October 14, 2022

El Paso County Development Services Department
Attn: Ms. Kari Parsons
2880 International Circle
Colorado Springs, CO 80910

SUBJECT: Grandview Reserve Filing No. 1
SF_Final Plat (SF-22-XXX) – Letter of Intent
SF-23-011

**Groundwater
Conditions** Fig. 3

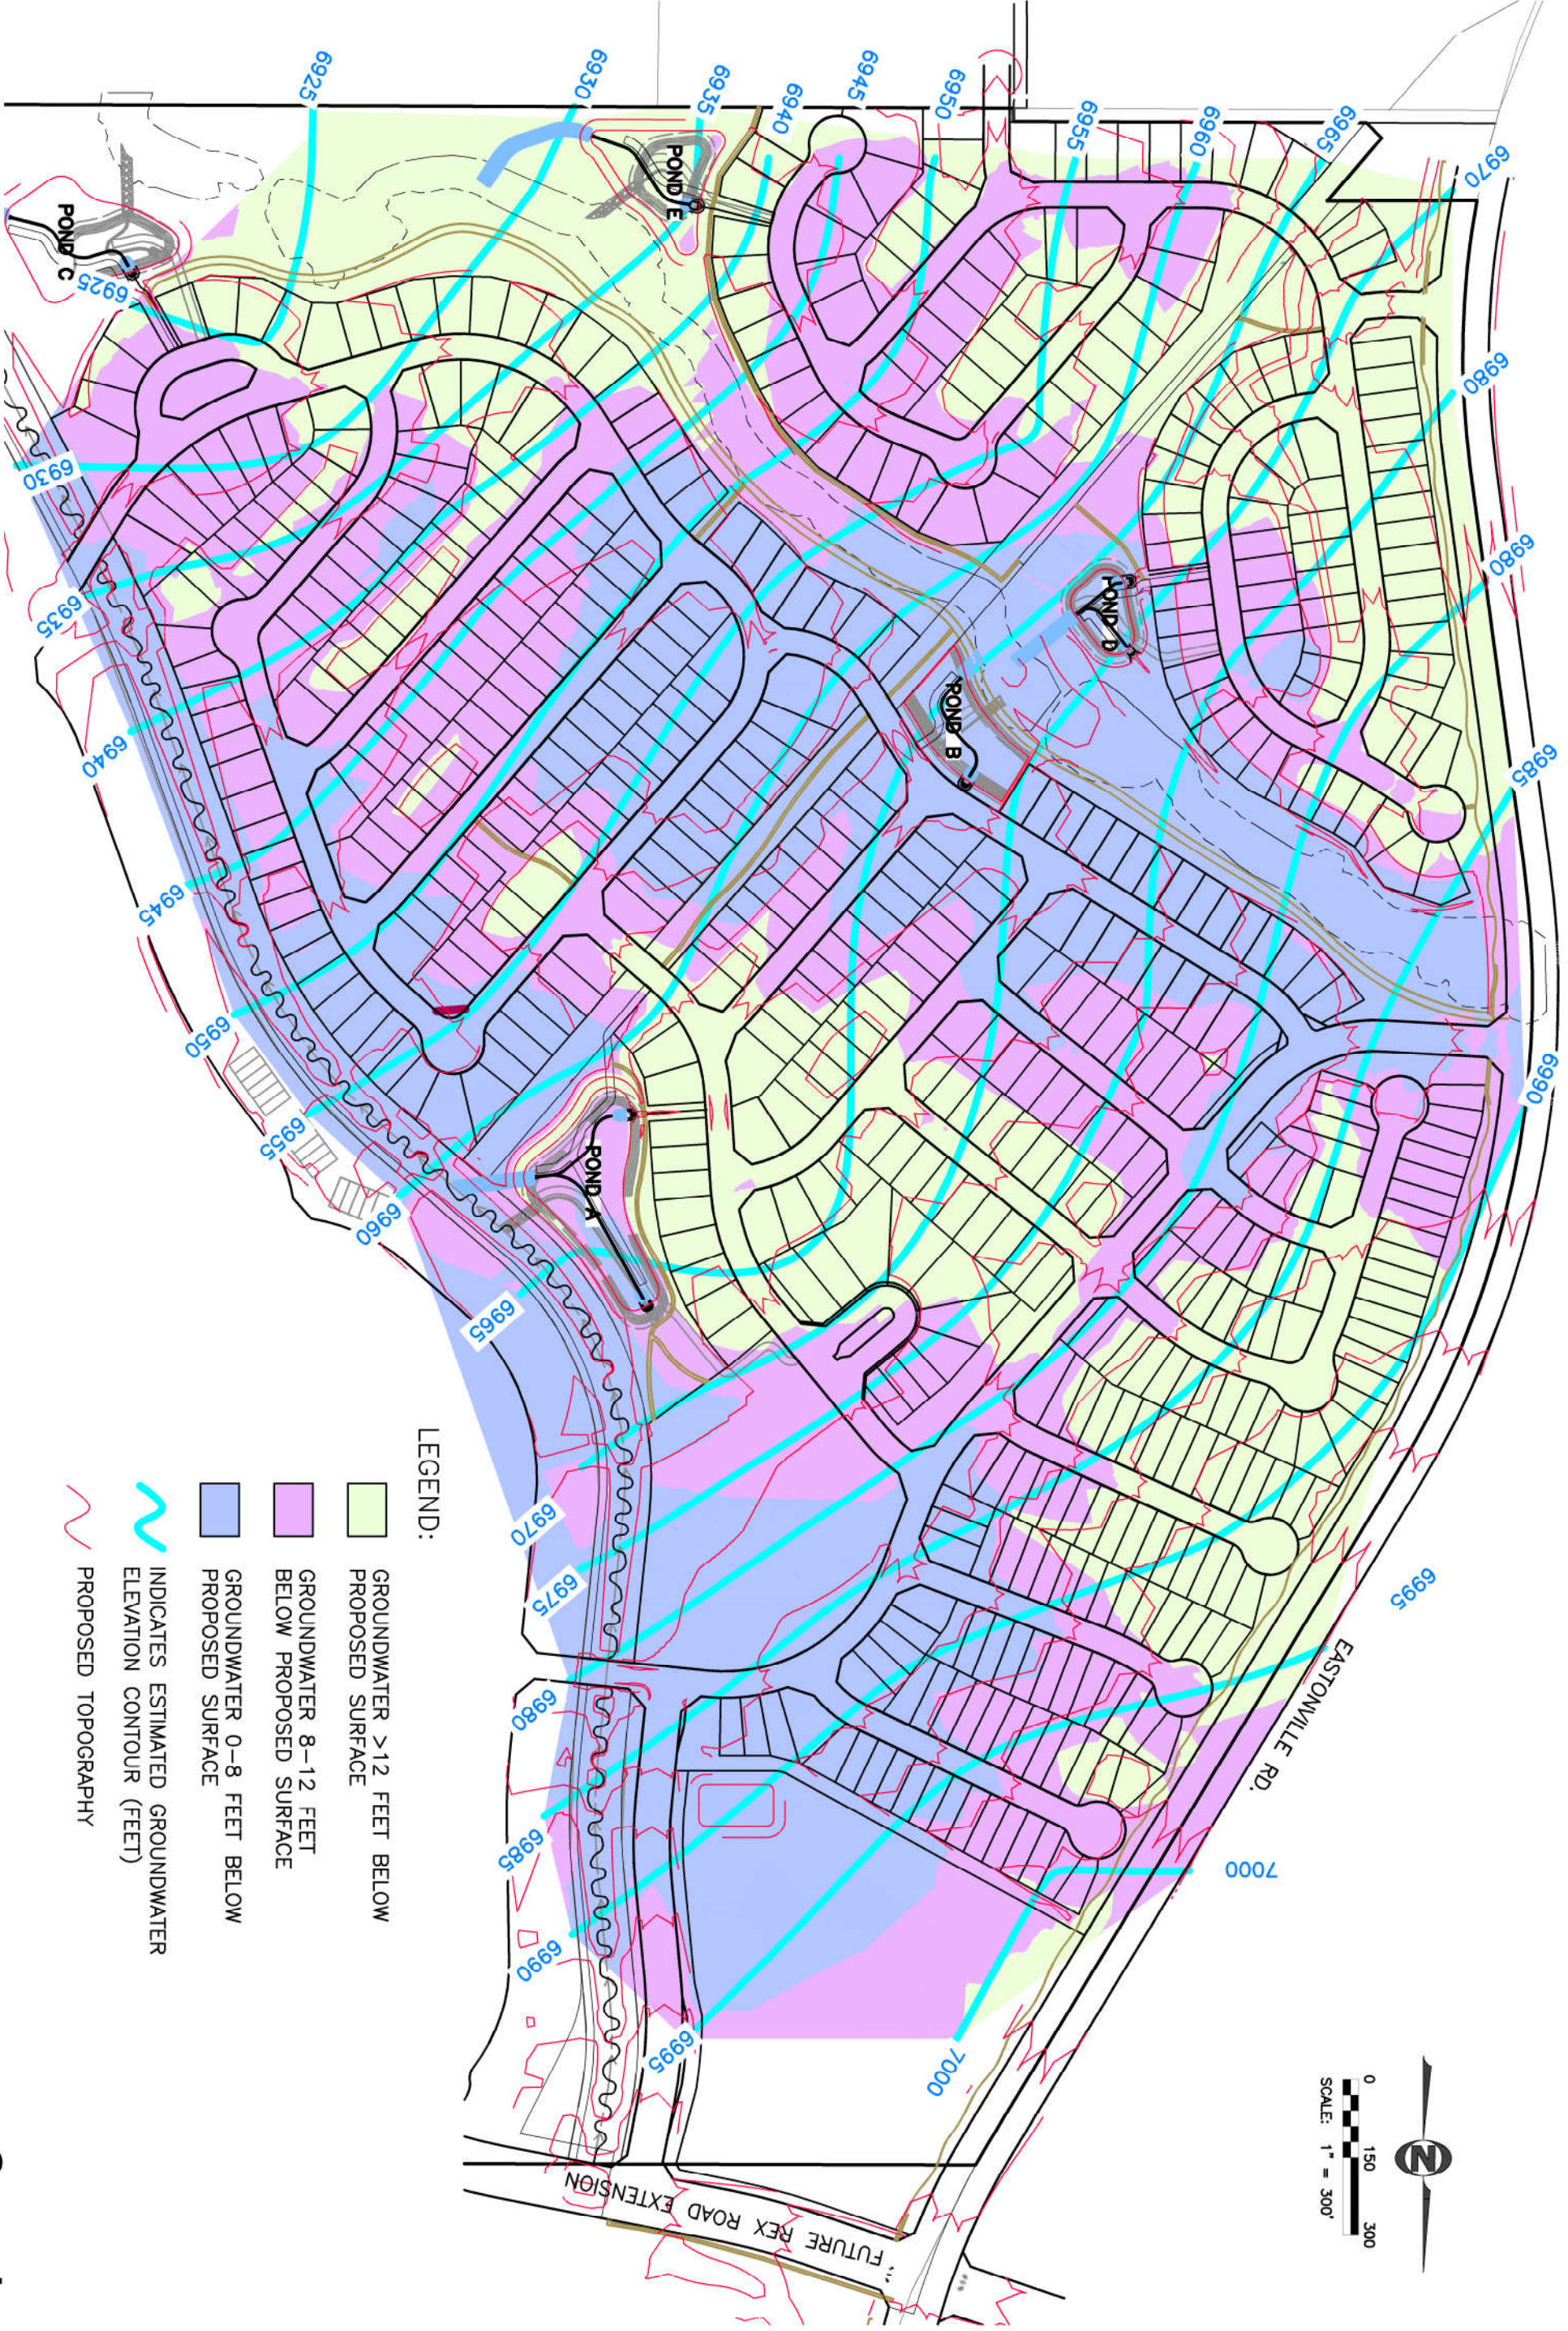
now is the time; this is the last step to entitling lots for sale; depict a plat note with no basements for certain lots

NOTE ADDED TO PLAT

CTL recommends the following lots avoid basement construction unless a groundwater monitoring study is performed at some future date and indicates the lot has adequate separation from groundwater.

- Lots 18-32, 44-54, 69-71, 76-88, 94-100, and 110-119.
